Addendum No. 1

RE: Contract # C204775

Dare County (HB-0017)

BRIDGE #9 ON US-64 IN MANNS HARBOR.

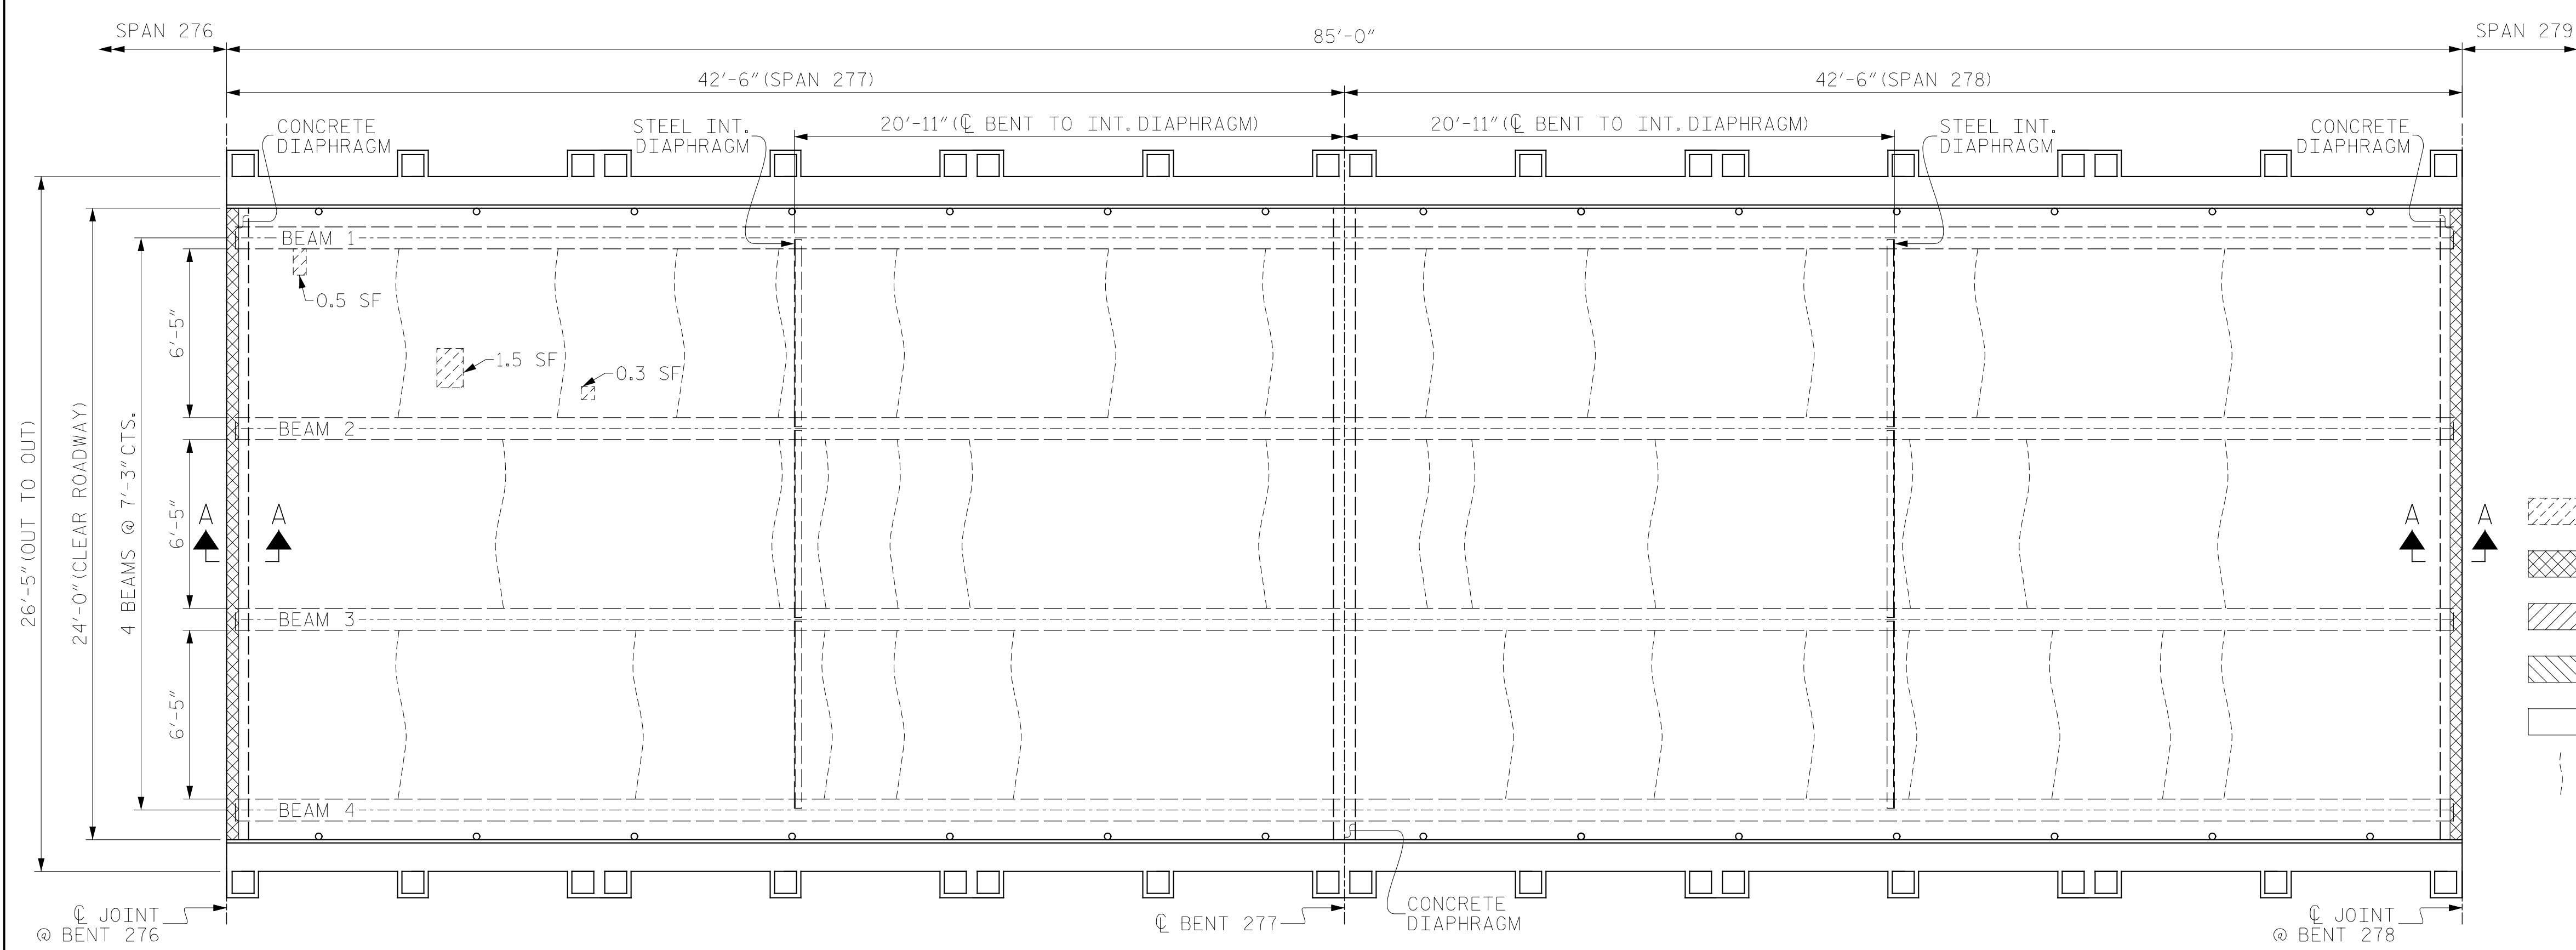
Sheet No.	Revision
S-1	Scope of Work notes: Notes 9 & 10 have been revised to remove Bent 165.
S-15	Bill of Materials: The Concrete Deck Repair for MMA Overlay quantity has been revised to 24.6 CF.
S-51	Summary of Quantities: The Concrete Deck Repair for MMA Overlay quantity has been revised to 1.7 CF for Span 126.
S-97	Summary of Quantities: The Concrete Deck Repair for MMA Overlay quantity has been revised to 0.1 CF for Span 275.
